Whiteswittes Cottage  
Hatfield Park  
Hatfield  
AL9 5NB

30<sup>th</sup> August 2010

Planning Applications: S6 2010/1711/FP

**Gascoyne Cecil Estates ["GCE"] Planning Application  
for Replacement Car Parks  
Application number S6 2010/1711/FP**

DRAWING NUMBER:
045-VC-002 B

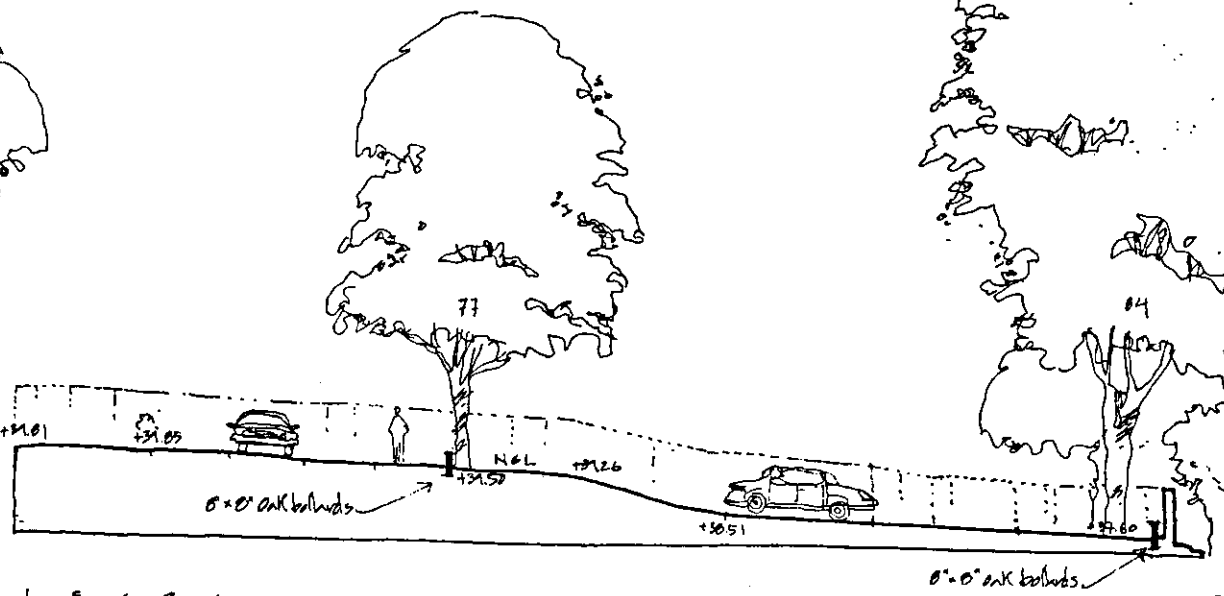
Firstly, the Plan Proposals Map [Figure 7, page 21] gives a misleading impression regarding the extent of the proposed car park, edged in red ink. As the Site Plan [Figure 6, page 14] clearly shows, the area comprising the proposed car parking bays for the residents of Park Row Cottages – the four semi-detached properties on the south side of the proposed car park- has been omitted on Figure 7. If these proposed car parking bays and two lane "new

**Secondly, although no mention is made in the Planning Application, the Site Plan [Figure 6, page 14] infers that the two lane private access road extends in a southerly direction beyond the residents' parking bays, through what appear to be substantial gates....into an unnamed, unmarked area. This area is the garden of Whitesmiths Cottage, the property that I rent from GCE. Currently, vehicular access to Whitesmiths is, and has been for many years, through the Carters Row "courtyard" into a single track driveway – a perfectly satisfactory arrangement. Why replace this with a two lane "new private access road" that would entail the "loss" of Park Row Cottages' rear gardens and much extra noise to the nearby residents of Park Close?**

CLIENT: THE GAILMINE CECIL ESTATE	
JOB: VIADUCT CAR PARK HATFIELD ESTATE	
DATE: APRIL 2010	SCALE: 1:250 @ A3
DRAWING TITLE: SITE PLAN	
DRAWING NUMBER: 813-VC-002 A

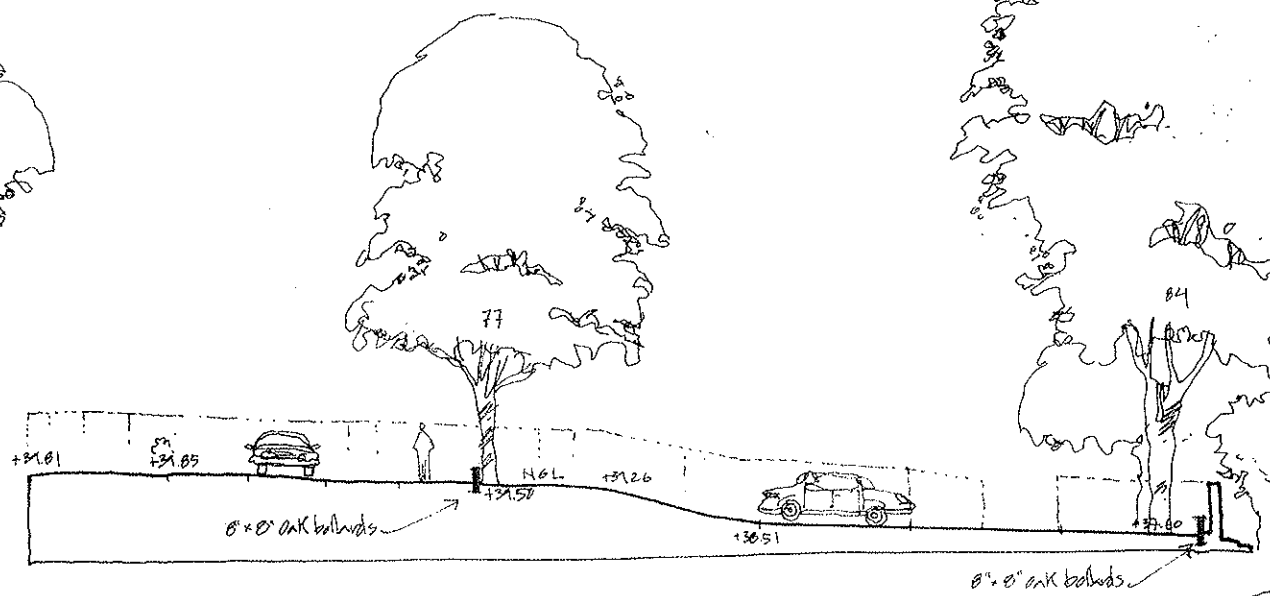
private access road" are inked in on Figure 7 it becomes immediately apparent that a considerable proportion of the existing rear gardens of these four cottages [in particular the more northerly cottages nos 1 & 2] will be lost to the development. All four cottages are owned by the Estate. Three of these cottages are currently unoccupied.

Why, unless there are as yet undisclosed future plans to extend the two lane access road a further 10 metres through Whitesmiths' garden into the adjacent large orchard area that extends to Fore Street?
